## CTC Bognor Regis and Chichester Part of Cycling UK

4 February 2017

**ReP/6/17/OUT Land North of Hook Lane, Pagham**

Figure 1: South Coast Cycle Route

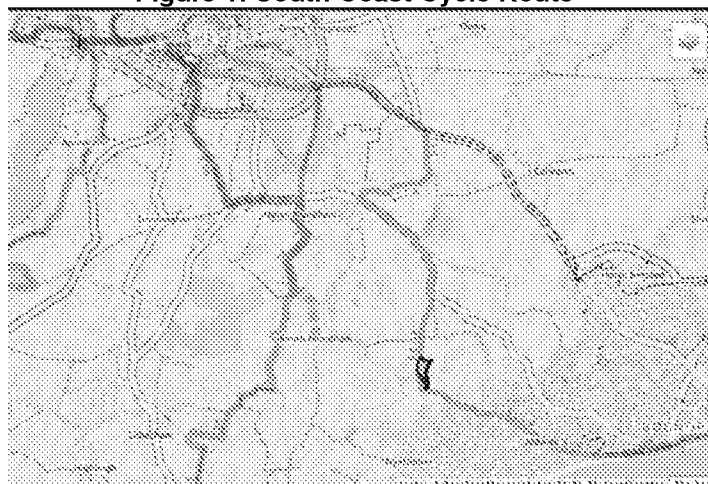
The Transport Statement for this development under Cycling states -

*3.6 The West Sussex County Council's Website does however identify a "South Coast Cycle Route which continues along Sefter Road and then northwards onto Pagham Road towards Chichester as shown in Figure 3 below*

The map of cycle routes in the Transport Statement shows the SSCR as going along the extremely dangerous Pagham Road which makes no kind of sense. This is believed to have been designated a long time ago possibly as much as 20 years and approved by West Sussex County Council. It is

not the the intended route of the National Cycle Network 2 (NCN 2) designated by Sustrans and also following the South Coast. That route was always intended to be from South Mundham south on Honer lane and then across a field to link with Summer Lane and on to Pagham. That route has been blocked by at least 15 years of landowner resistance and now lack of funds. To clarify the status of the NCN 2 it should be noted that this is a long distance National cycle route which, when complete, will link Dover in Kent with St. Austell in Cornwall via the south coast of England. The route can be viewed on a map on the Sustrans Website and this does not now show the route following the Pagham Road but shows a gap. From Exeter to Dover there are very few gaps left but one of them is from South Mundham to Pagham and Bognor Regis. See

The completion of the cycle route from South Mundham to Pagham would substantially alleviate the affect on local cycling of this development and if the Council decides to grant Planning consent it should only be with a s106 agreement to provide the funds for route completion and if appropriate jointly with any of the other developments mentioned if they receive consent.
